# A47 Wansford to Sutton Dualling

**Scheme Number: TR010039**

## **9.24 Applicant's Response to the Examining Authority's Further Written Questions (ExQ2)**

April 2022

Drawing Title: **CROWN LAND PLANS  
REGULATION 5(2)(n)  
SHEET 1 OF 7**

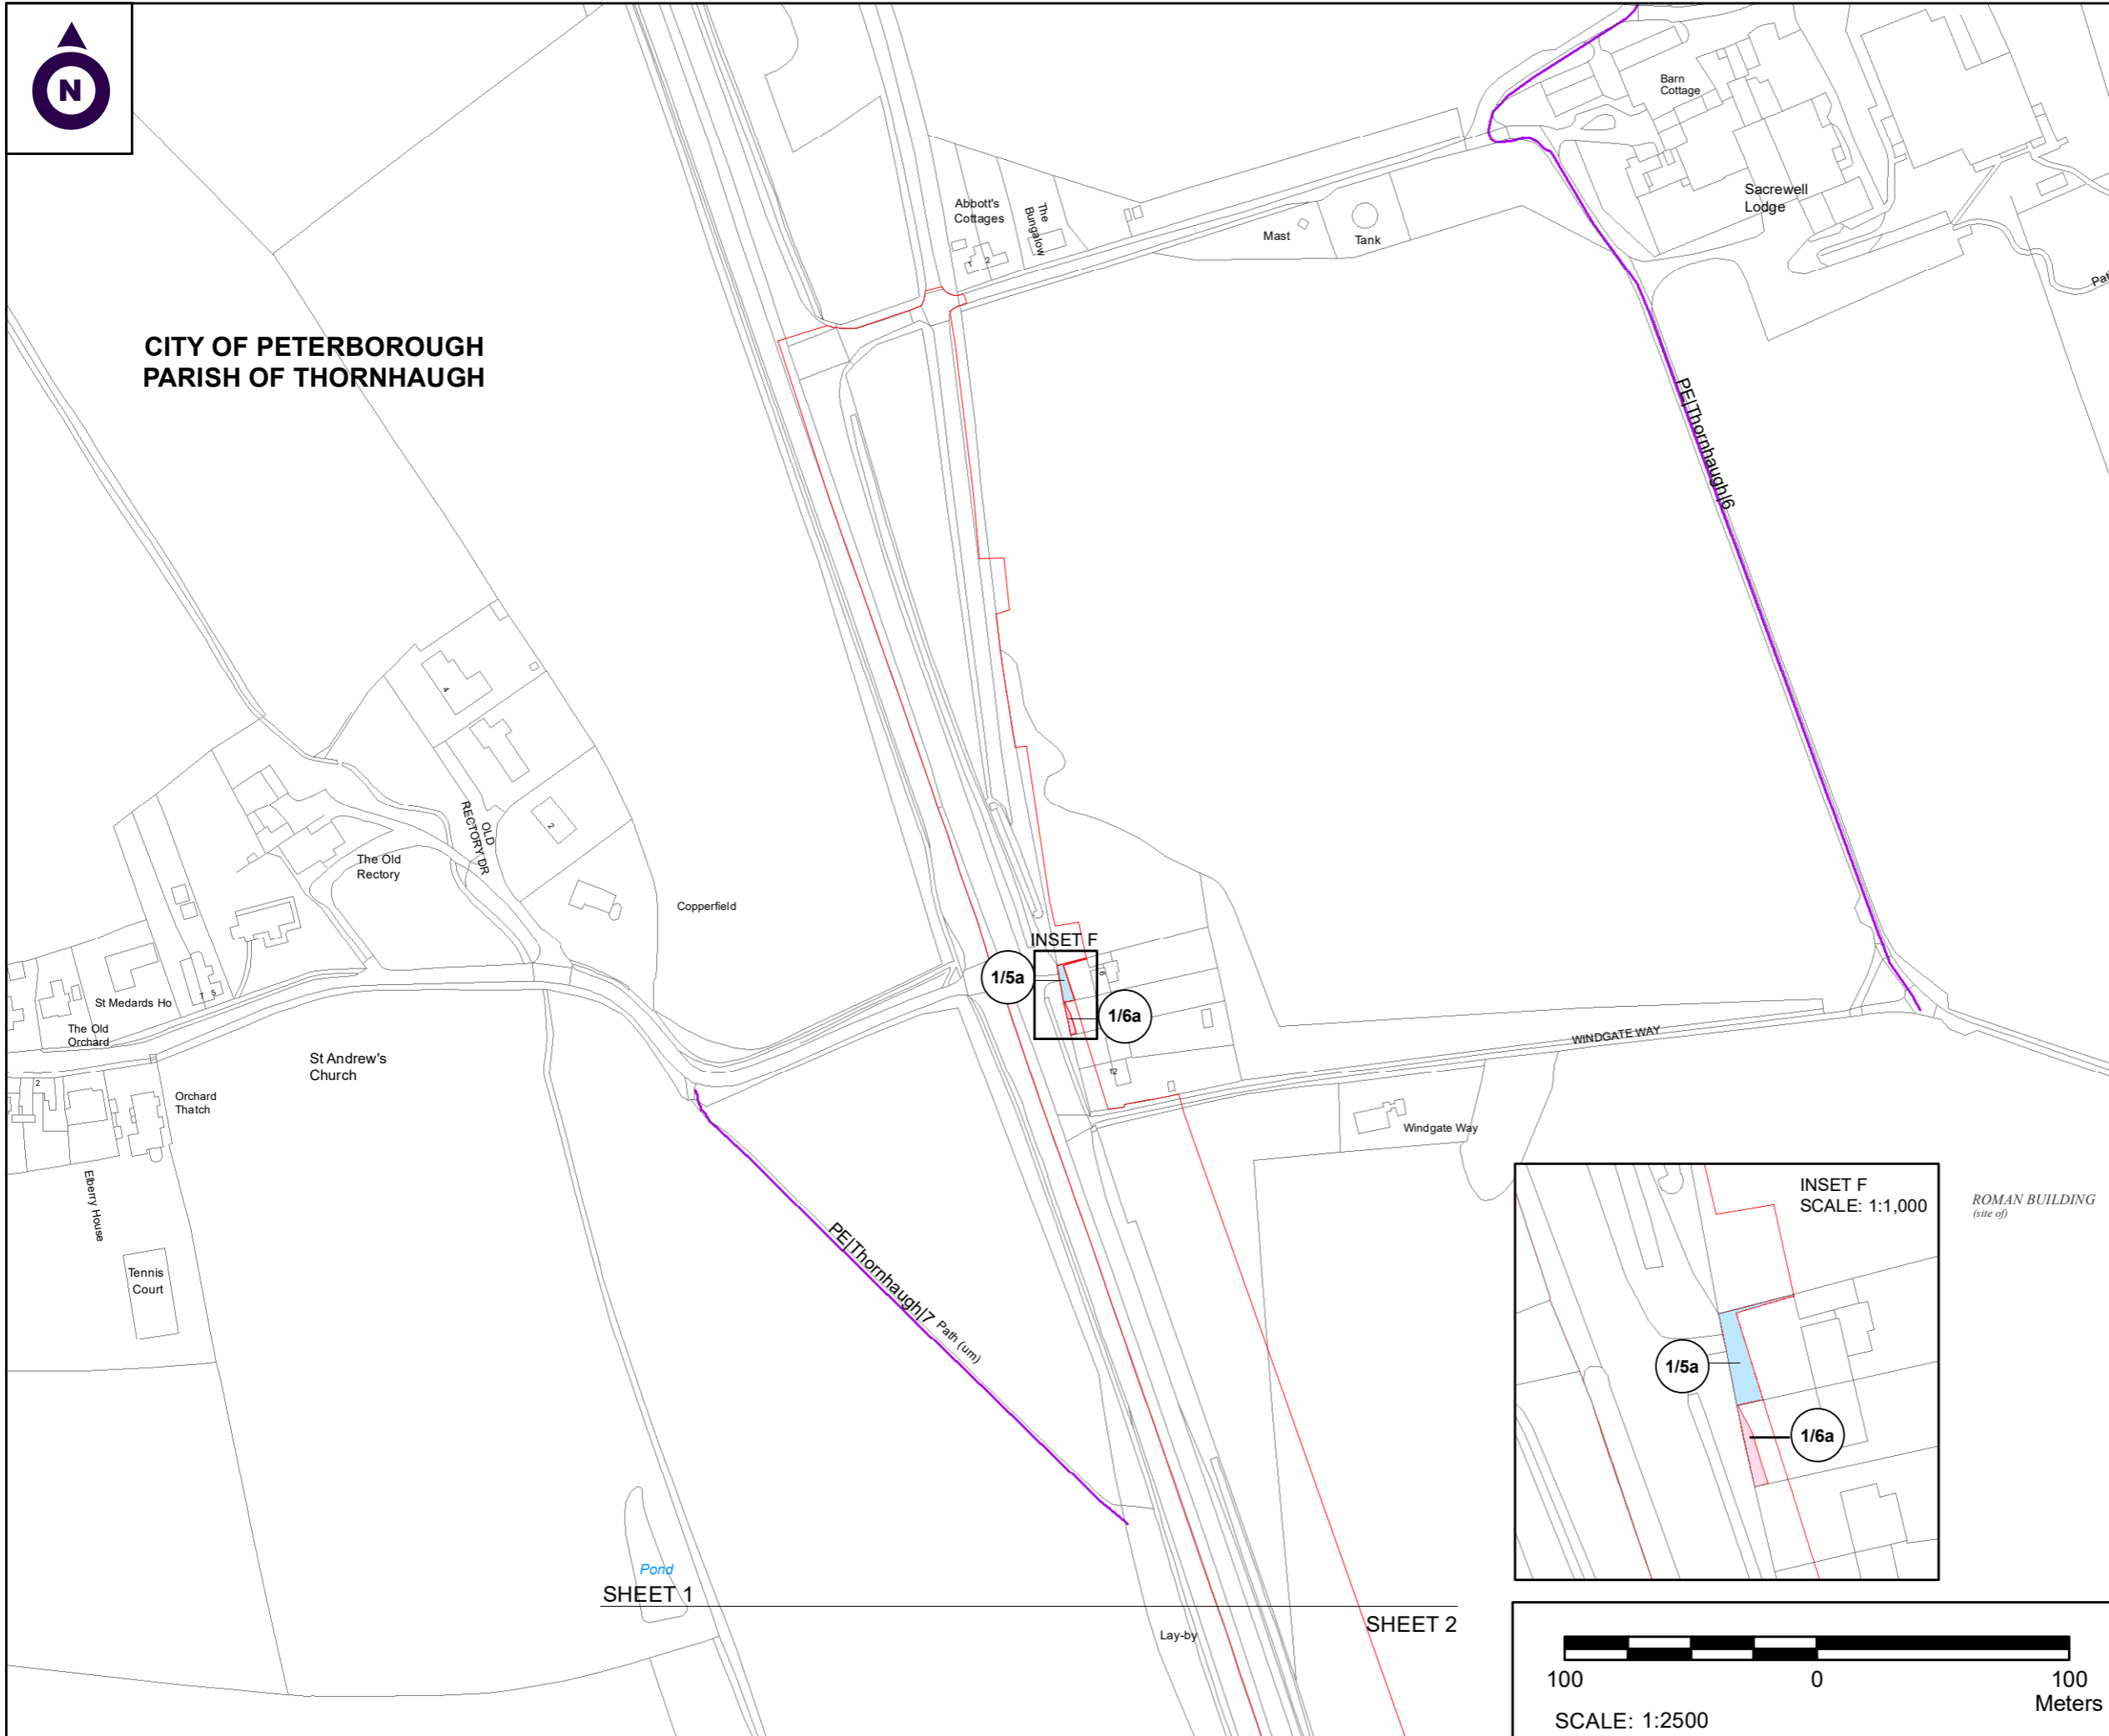
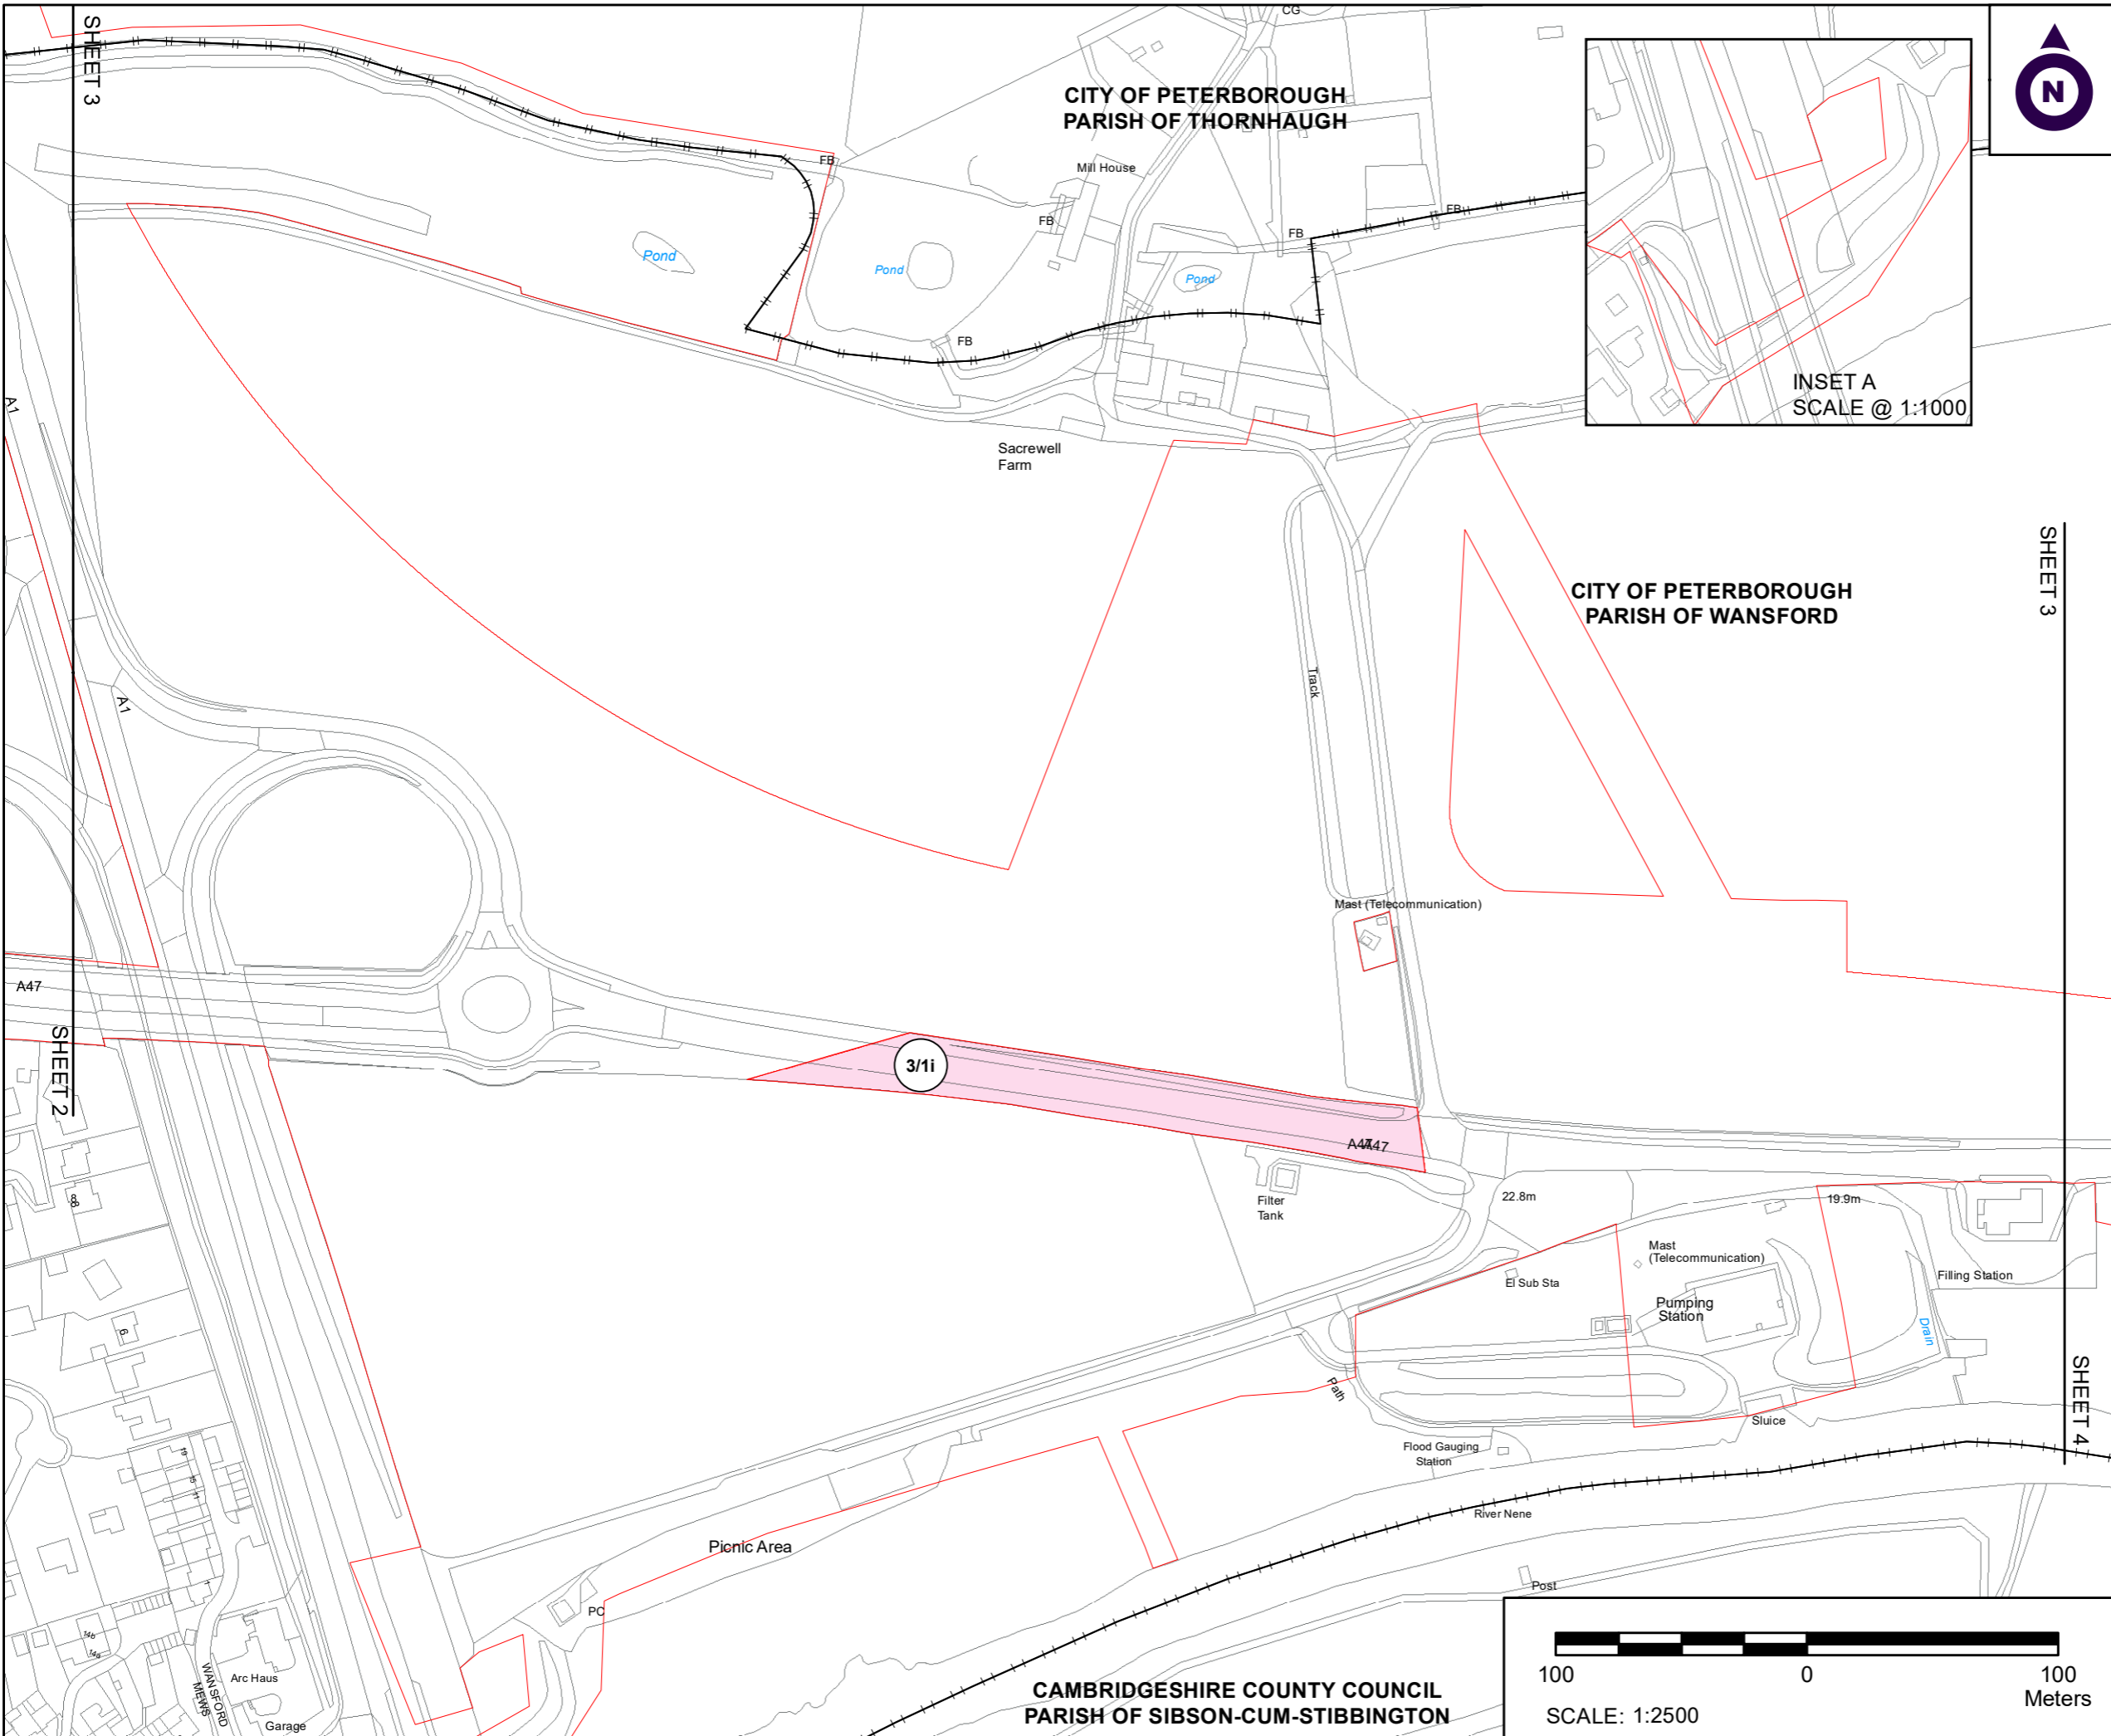
2.3.5.	The Applicant	<p><b>Land Plans</b> [REP2-003] and <b>Crown Land Plans</b> [REP2-007]</p> <p>a) The shape of Inset F showing the area around 6 – 12 (evens) Great North Road is not the same as that on the plans and includes additional land. Can these please be aligned?</p> <p>b) The same applies to Inset A on Sheet 5.</p> <p>c) Could Sheet 3 Inset B on Sheet 2 please be made larger and also the “cut-line” shown on Sheet 3 included.</p> <p>d) Neither Inset A nor Inset C on Sheet 6 appear to have been identified on the main plan. Could this please be included.</p>	<p>The Land Plans (<b>TR010039/APP/2.2 Rev 3</b>) and the Crown Land Plans (<b>TR010039/APP/2.8 Rev 2</b>) have been updated and submitted at Deadline 5 to address these points.</p>
